**Consultation Response from KC,
Highways Development Management**

2025/92459 10A, Regent Street, Heckmondwike, WF16 0HD

Change of use of taxi booking office and car park to hand car wash

Revised Plan Ref: 2538 0001A; Vehicle Accumulation - Car Wash Regent Street, and Regent Street Technical Note Rev 1.

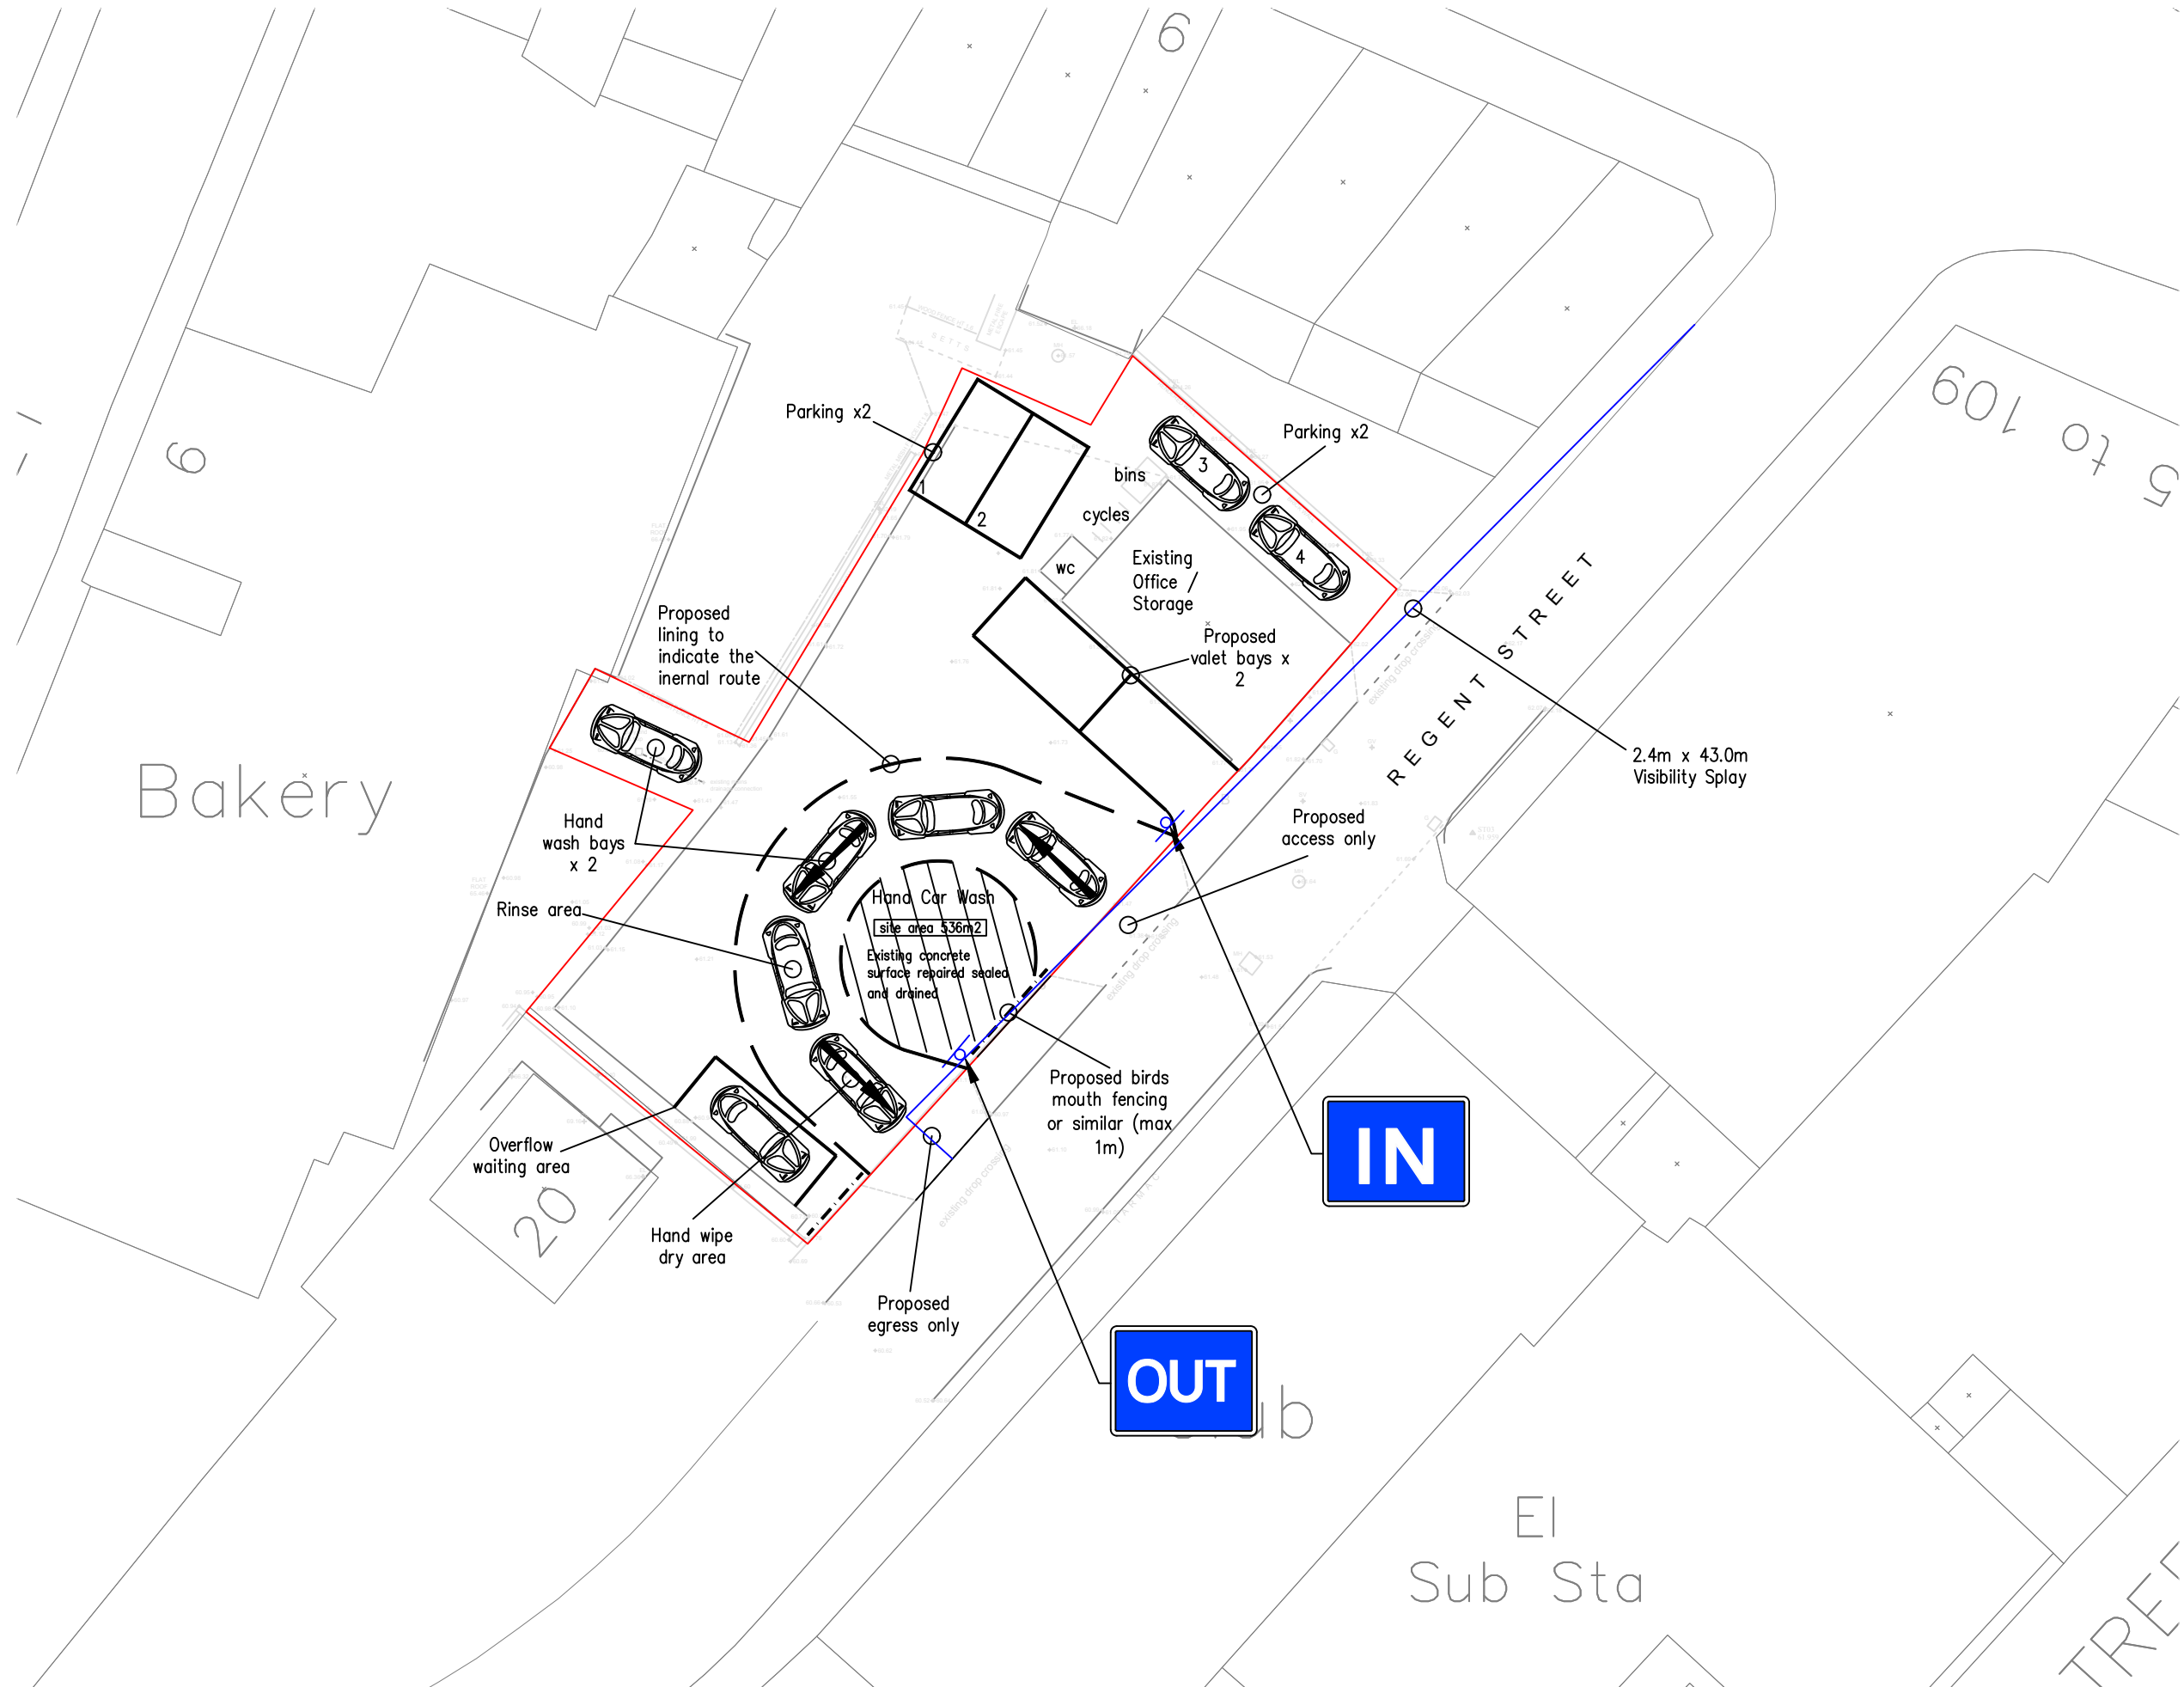
HDM notes the revisions and explanations in Rev 1 of the Technical Note, Proposed Vehicle Accumulation - Car Wash 10A Regent Street, Heckmondwike, and shown on the layout Drawing 2538 0001A. The proposal continues to indicate an in and out arrangement with an internal anticlockwise one-way loop layout. The layout now shows that there could be capacity for up to seven vehicles progressing through the washing process, plus other manoeuvring, and parking space. Additionally, further analysis of the predicted vehicle accumulations within the proposal site indicates that the maximum accumulation outside of the traditional weekday peak hours is likely to be between four and five vehicles to suggest containment within the site.

HDM agrees that the operation at the proposed car wash is likely to be efficient and contained within the site now, reducing the risk of queue spill back onto Regent Street and impact on the town's traffic circulation system. Furthermore, these details are enough to overcome the highway objection. There being insufficient grounds now to defend a recommendation of refusal since it is demonstrated that there would not be severe adverse impacts on the transport network in terms of capacity, congestion or cumulative. Additionally, there is no evidence presented to indicate that there would be an unacceptable impact on highway safety.

Accordingly, no objection is raised.
